PLANNING AMENDMENT

Application No: H18-0245-11/A1

APPLICANT NAME AND ADDRESS G Sangha		AGENT NAME AND ADDRESS G R merchant	
Telephone:		Telephone:	
SITE ADDRESS DETAILS 112 Bridge Road, Sutton Bridge			
CURRENT APPLICATION NO: This amendment cannot be considered unless the relevant reference is stated.		H18-0245-11	
Building Regulation reference relating to same development (if applicable)

From: G R Merchant Ltd [gr.merchant@btconnect.com]
Sent: 03 May 2011 16:37
To: Gedney, David
Subject: Re: H18-0245-11. Revisions to scheme, 112 Bridge Rd, Sutton Bridge - G Sangha

PROPOSED SIDE ELEVATION 1:100

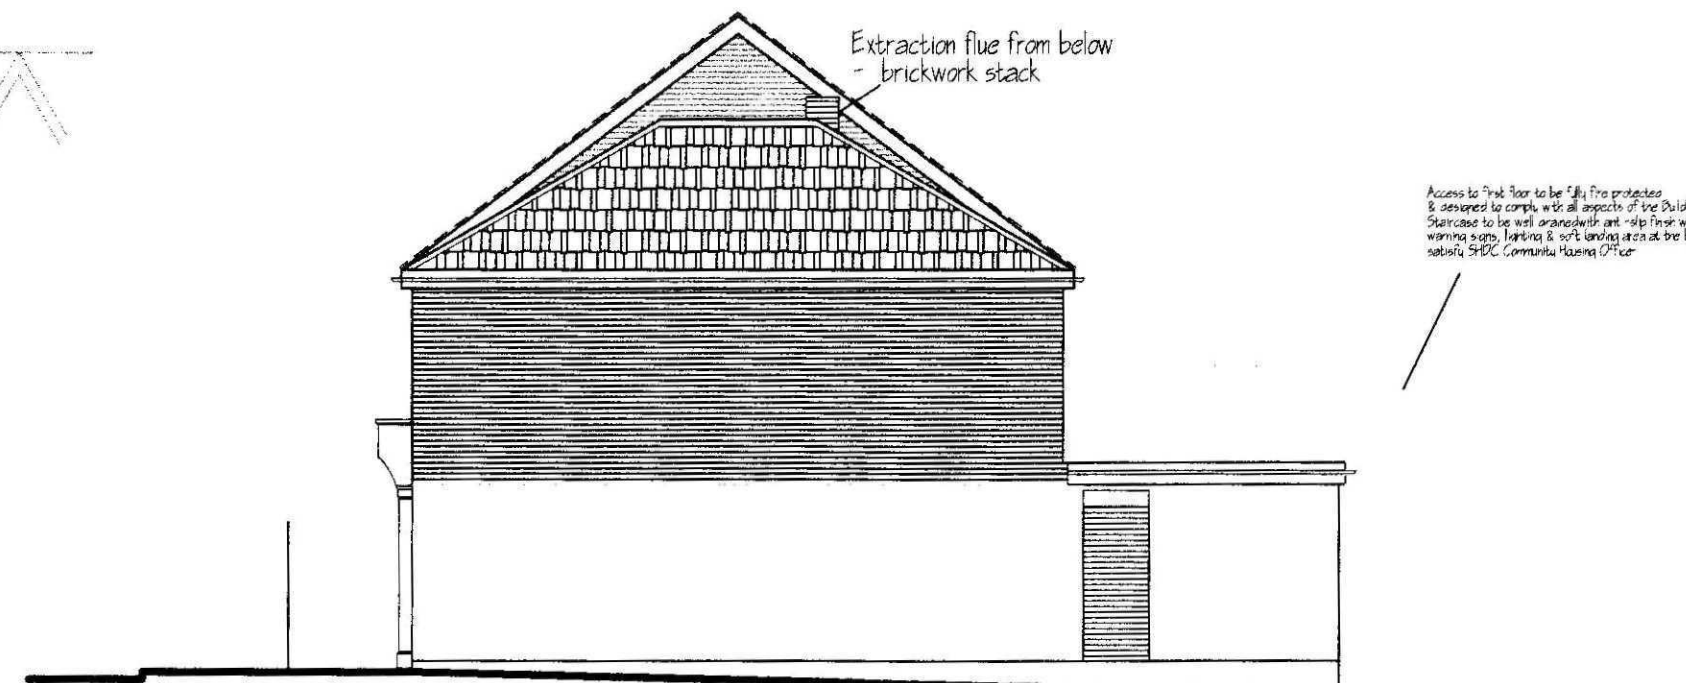
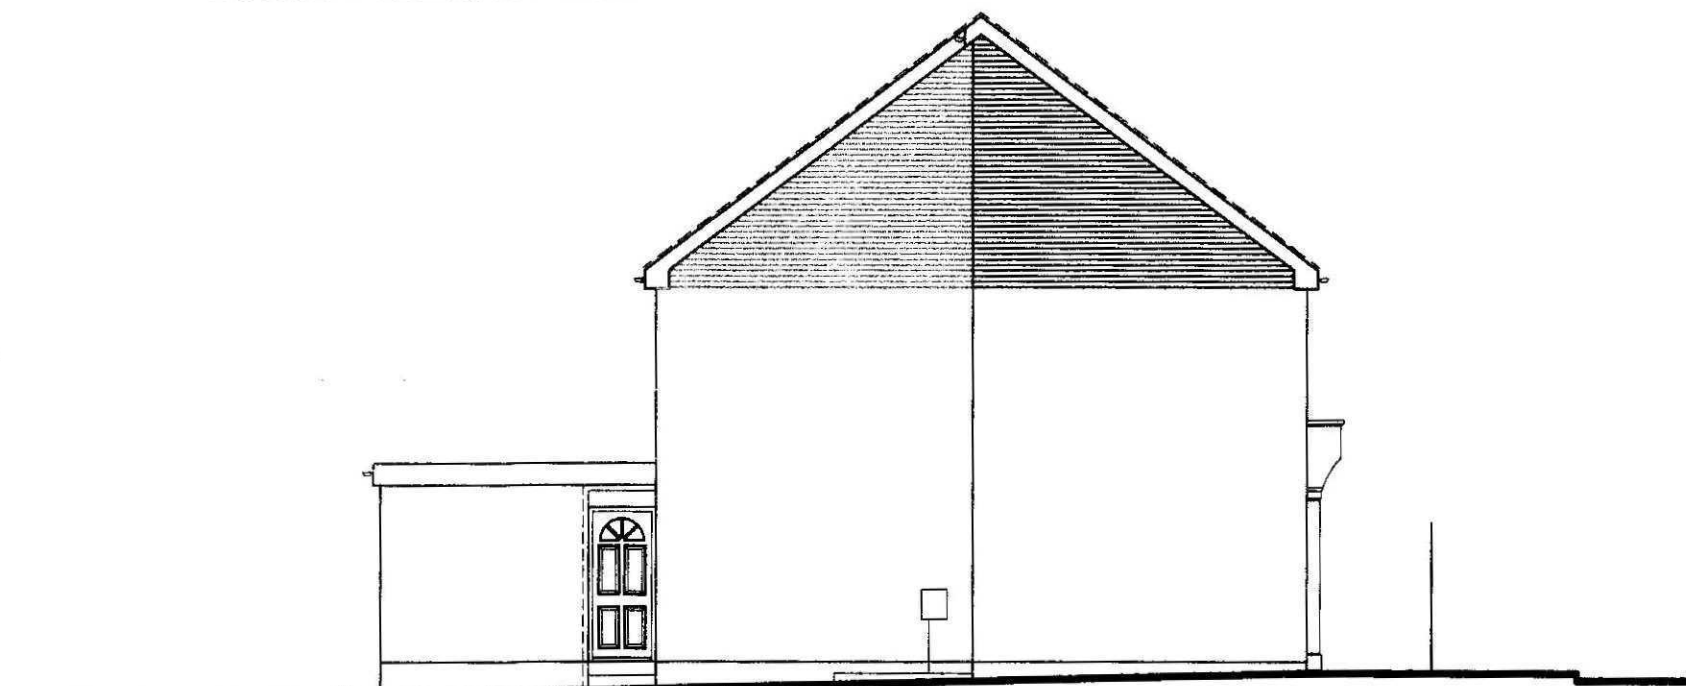
FULL DESCRIPTION OF DEVELOPMENT OF CURRENT APPLICATION THAT THIS AMENDMENT RELATES TO		change of use of Shop - - - -	
State details of amendments proposed. (Give a full detailed list of the changes, and also mark these clearly on the accompanying plans. Only the changes listed here will be considered)		Omit door on Side elevation	
State drawing numbers of the current submission			
Has this amendment been requested by the Council? (If so, state Officer dealing with the application)	YES/NO		
Describe any part of the original development which is excluded by virtue of the amendment, and state any alteration to plot numbers			
Has a similar amendment been submitted under Building Regulations? (If so, state Building Control Surveyor dealing with application)	YES/NO

> Dear Bob,
>
> In respect of the above application, it appears that the elevational
> drawings omit a new door on the side elevation. I therefore look
> forward to a revised plan that addresses this issue.
>
> It is assumed from the drawings that the width, depth and height of
> the buildings remains the same as previously approved (ref
> H18-0783-10) and that the only alterations are as follows:
> - Revised shopfronts
> - Revised rear external staircase, position of rear door and addition
> of side door (store).
> - Revised internal layout at ground floor only
>
> Can you please confirm (or otherwise).
>
> Regards.
>
> David Gedney.

With respect to your e-mail with reference to the above, please find attached amended drawing as requested.
